Application for a non-material amendment following a grant of planning permission.

Number	7
Suffix	
Property name	Windlesham
Address line 1	St Winefrides Road
Address line 2	
Address line 3	
Town/city	Littlehampton
Postcode	BN17 5NL
Description of site location must be completed if postcode is not known:	
Easting (x)	503377
Northing (y)	101728
Description

Singe storey rear extension to create kitchen family room. Single storey extension to rear of existing garage.

Reference number:	LU/371/19/HH
Date of decision	10/02/2020

Drawing Number: 1214.02.e

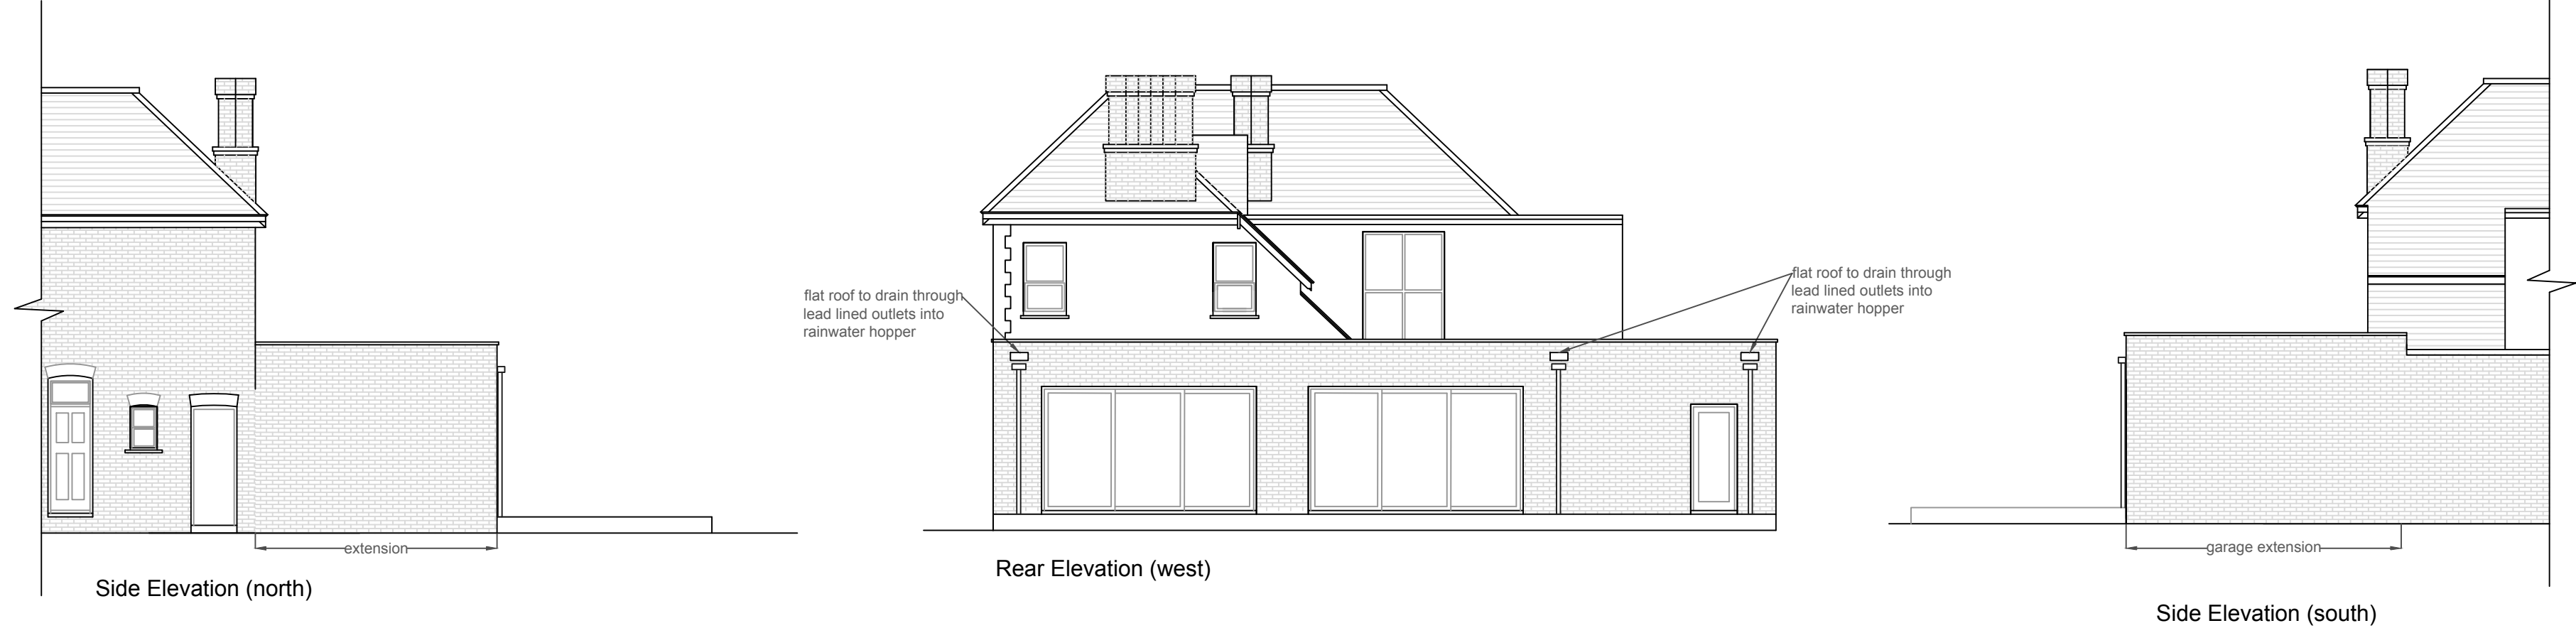
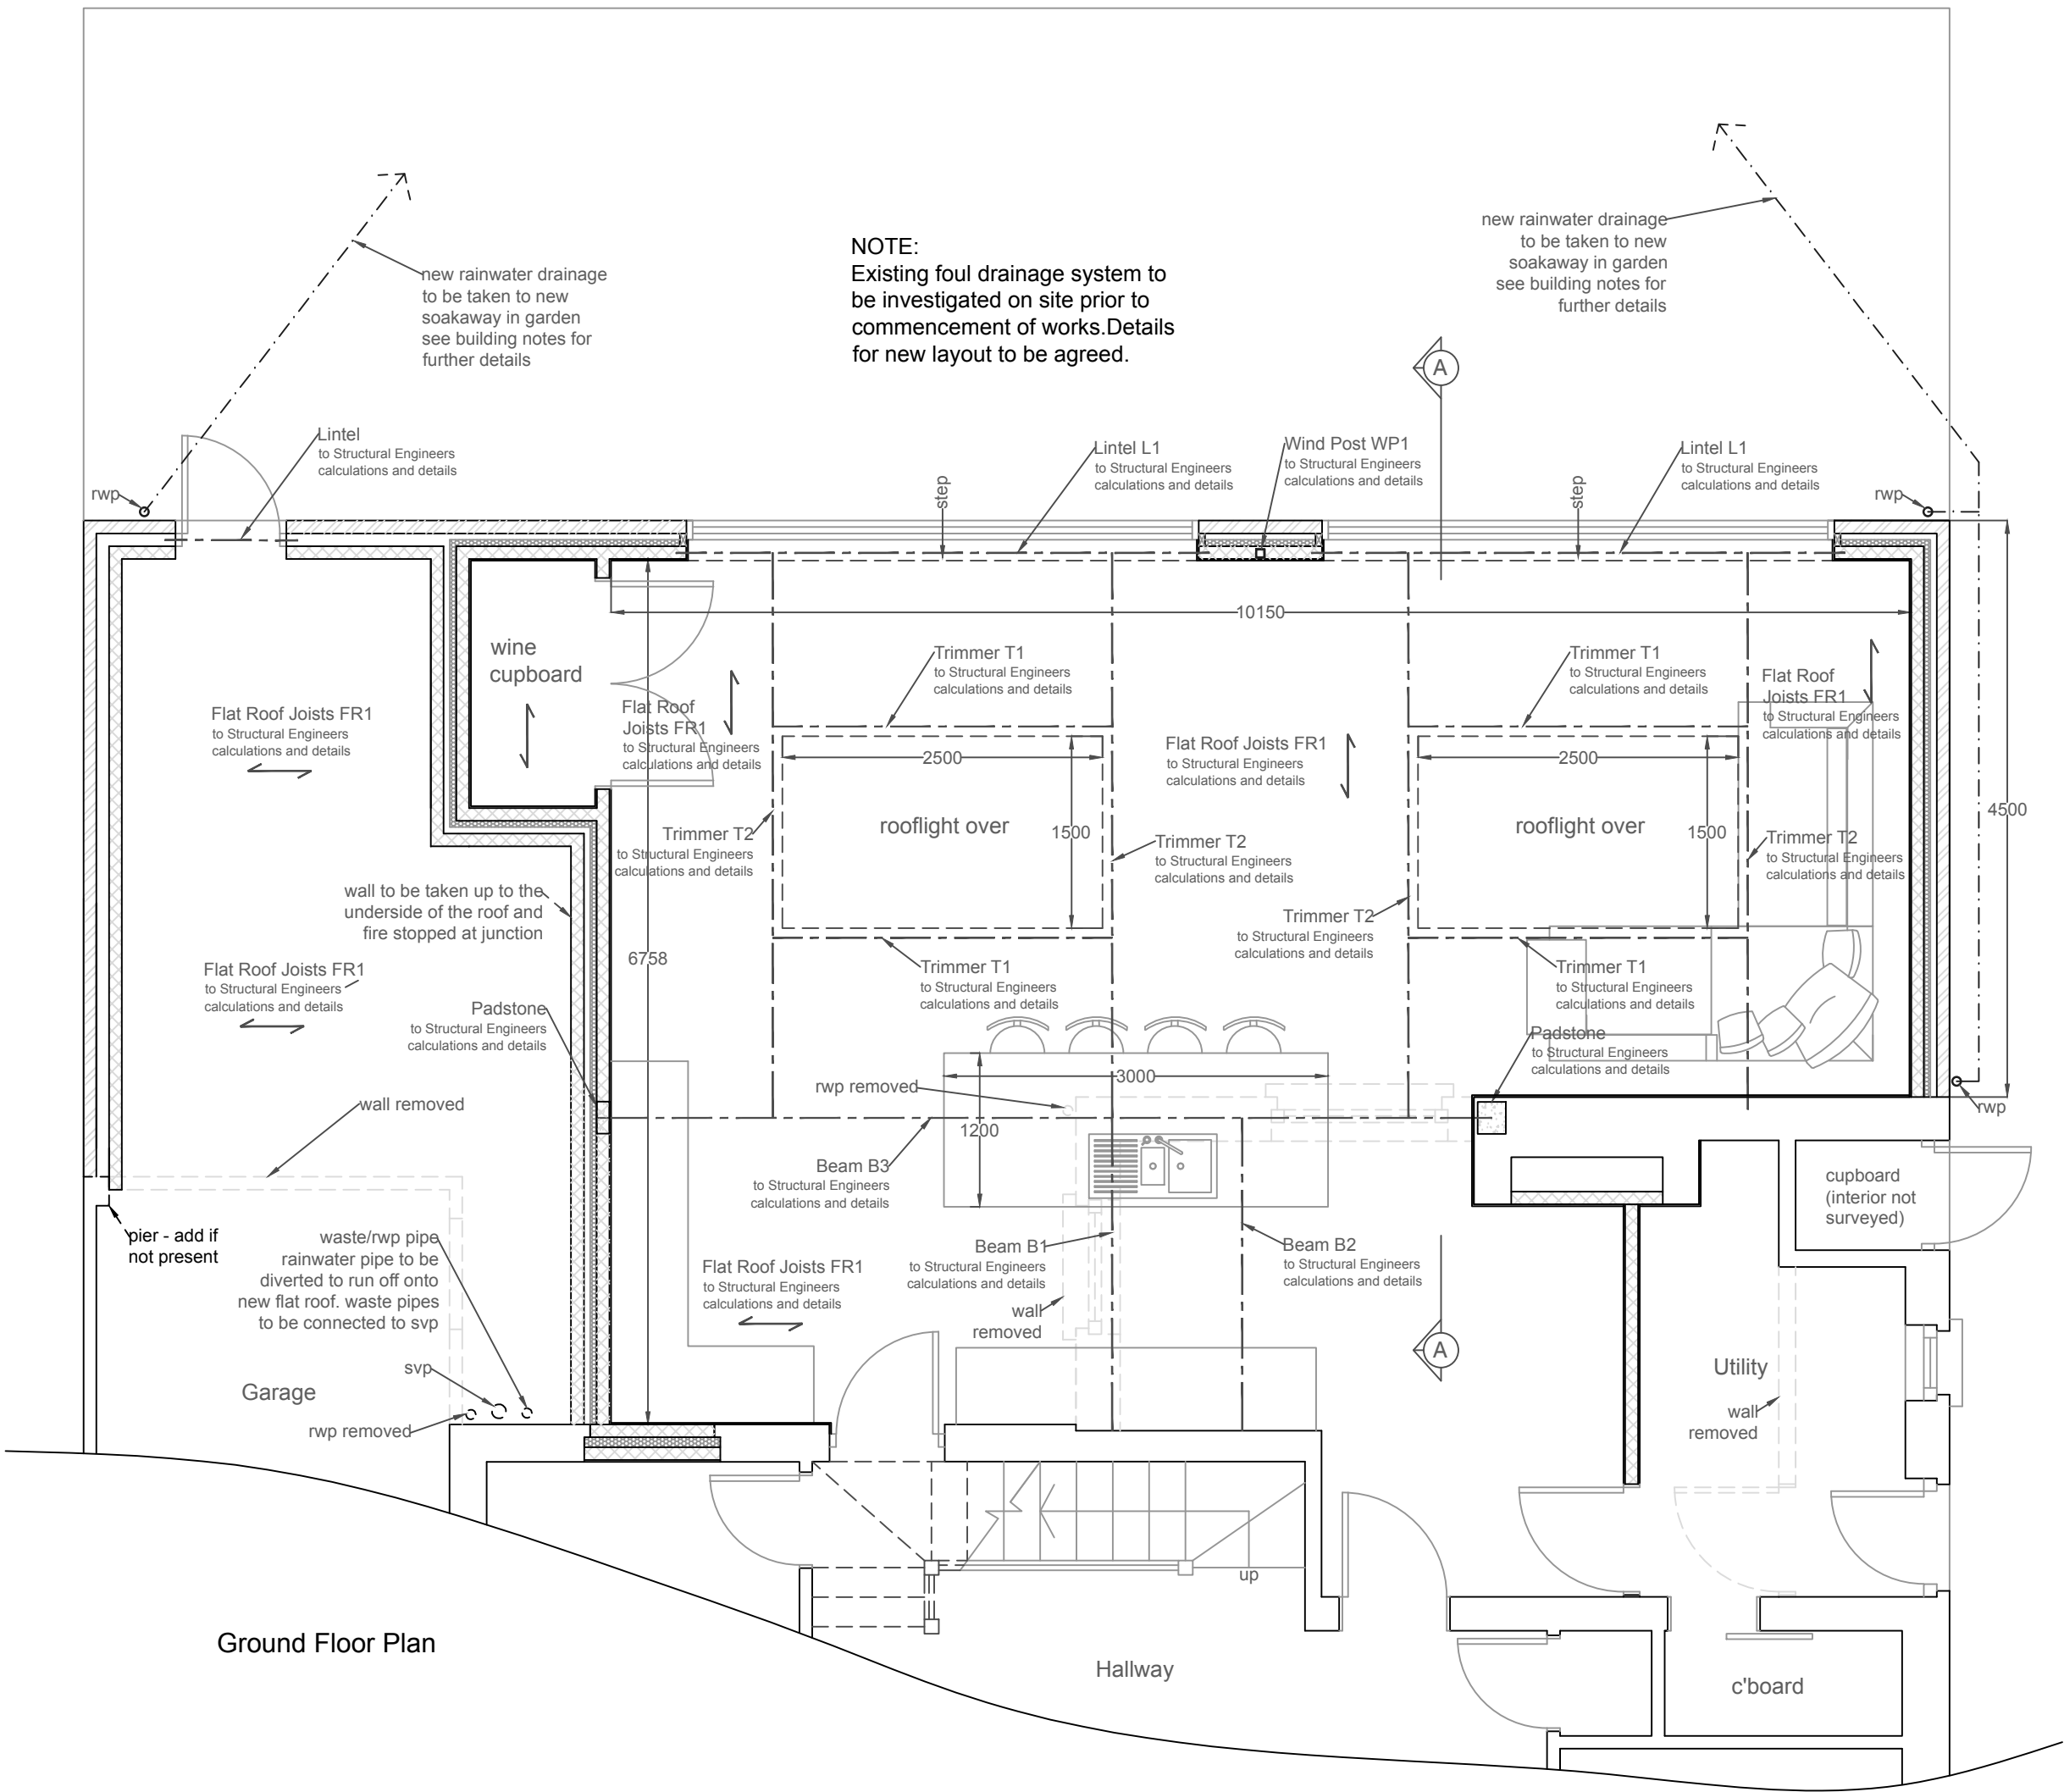
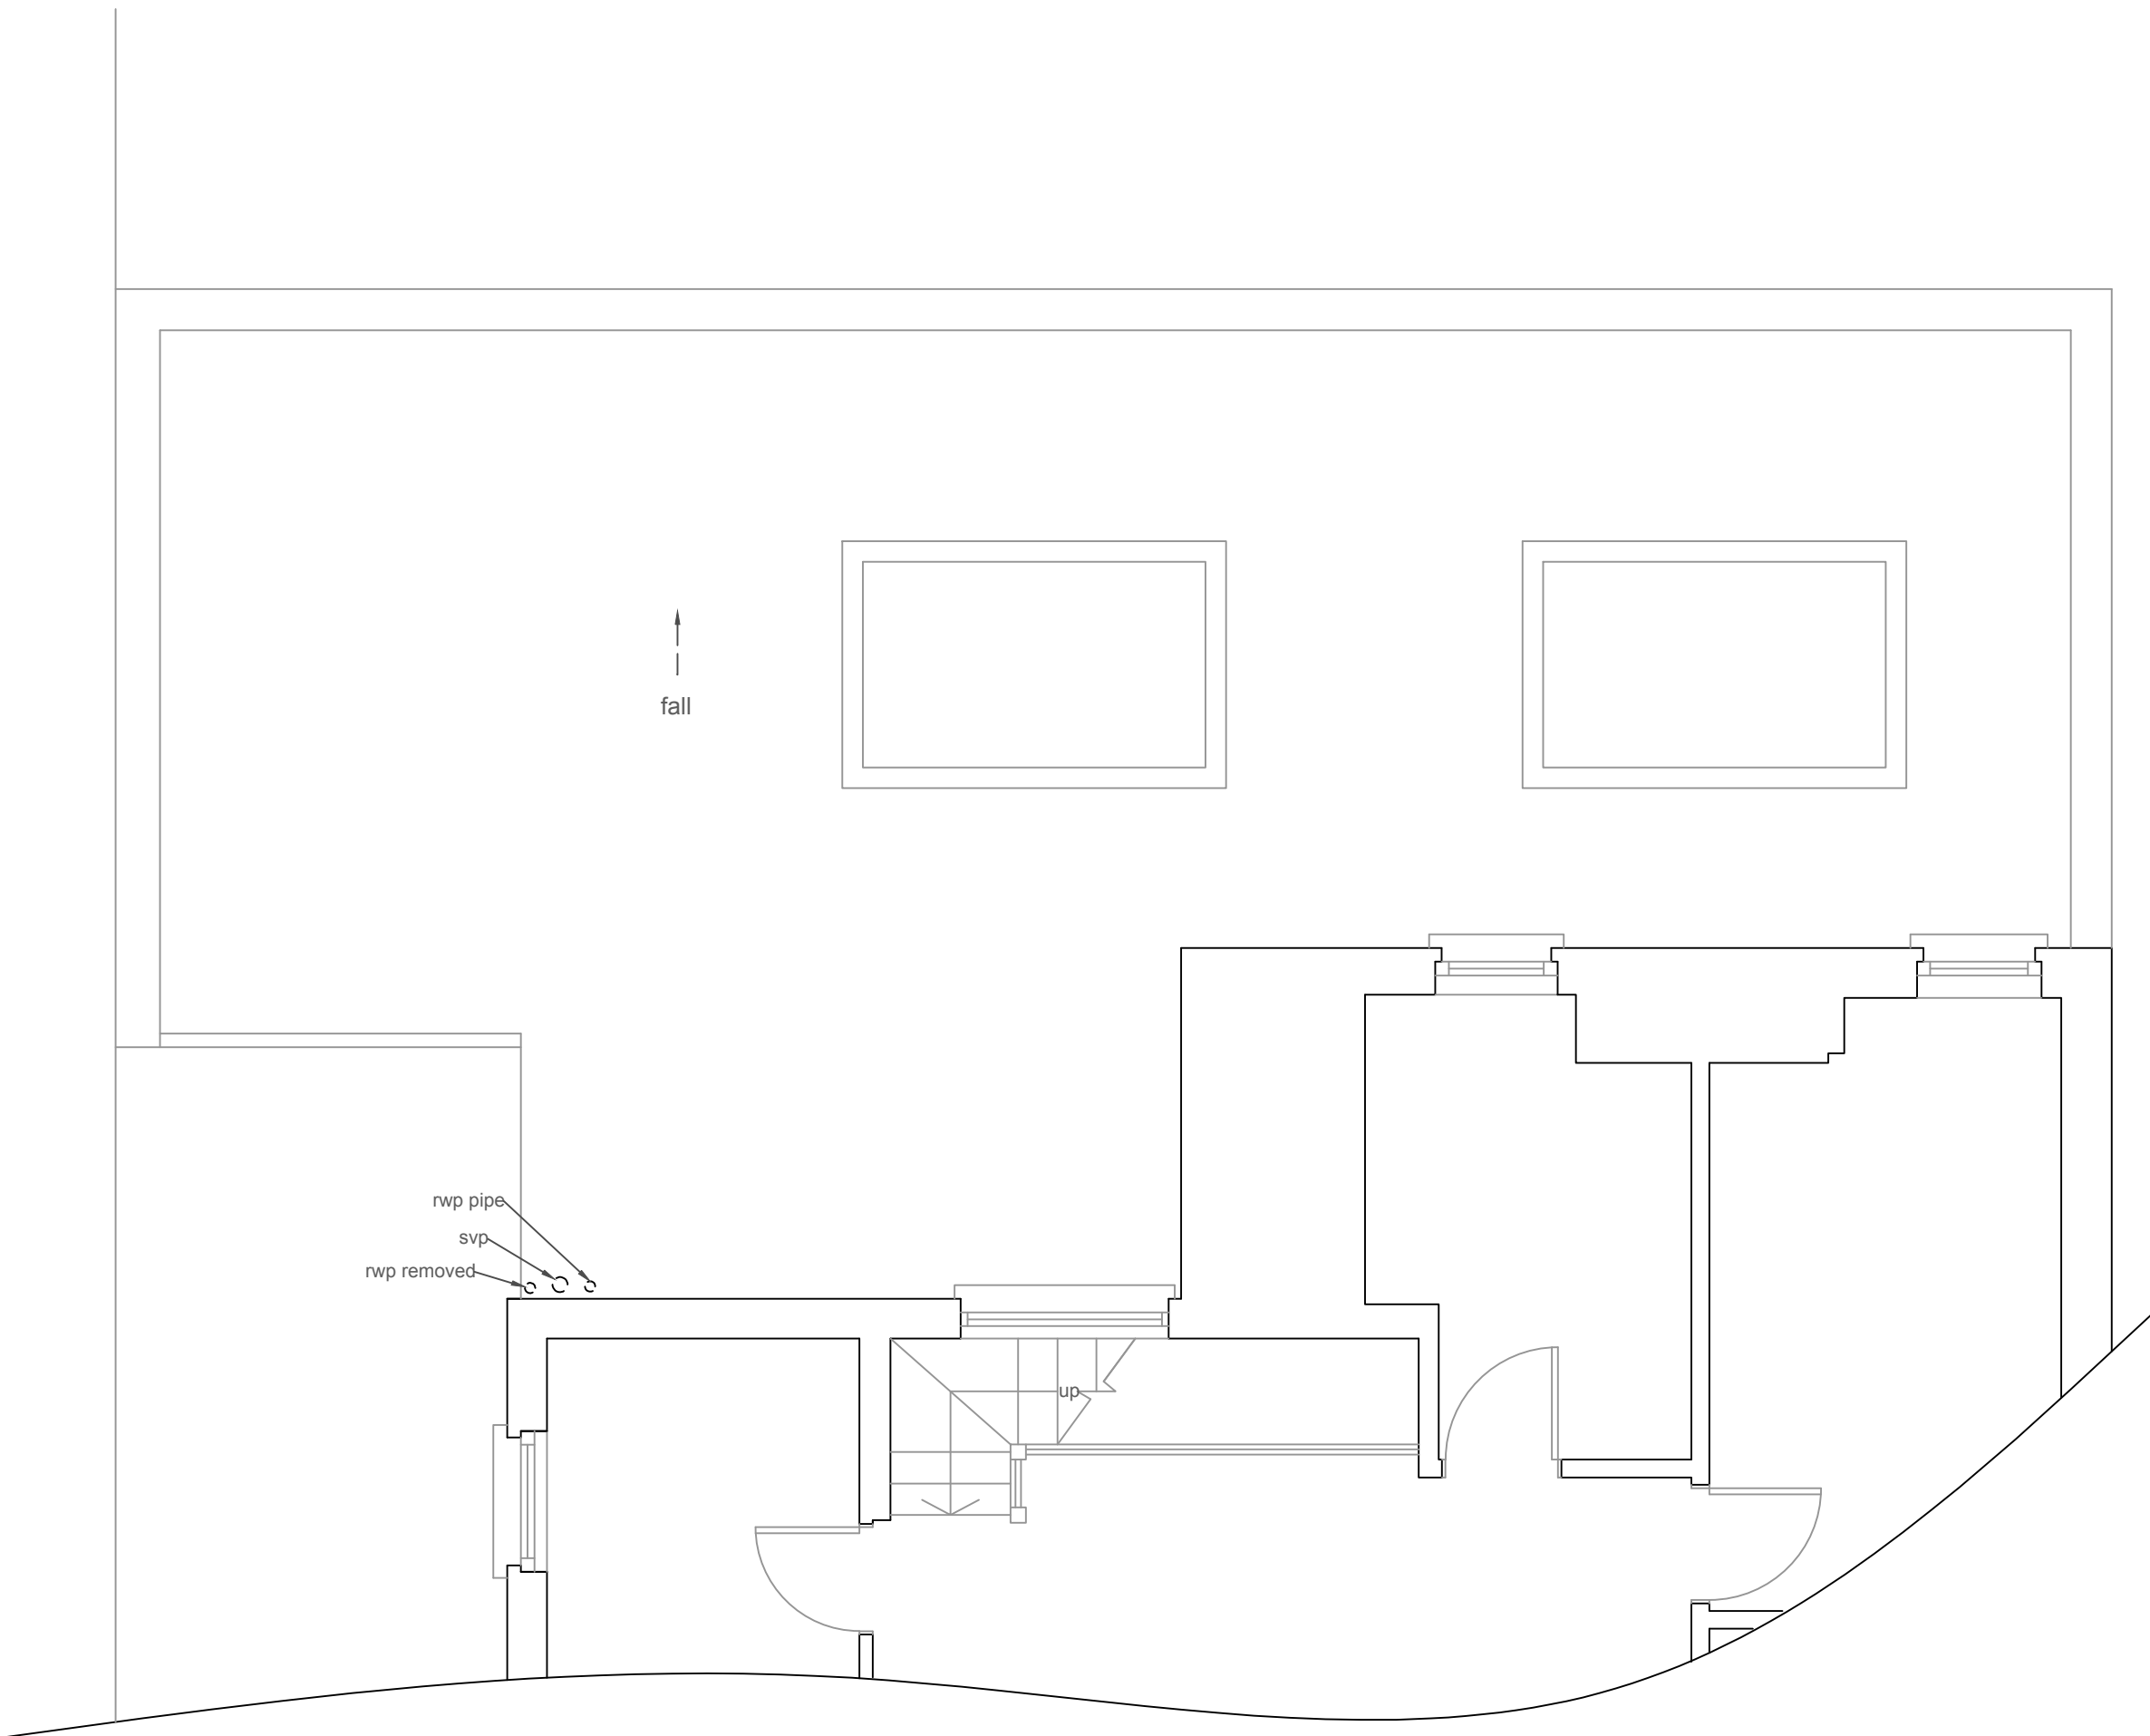
Replacement of previously proposed false pitch to perimeter of extension with parapet wall.

It is felt the appearance with the parapet is more in keeping with the style of the extension.
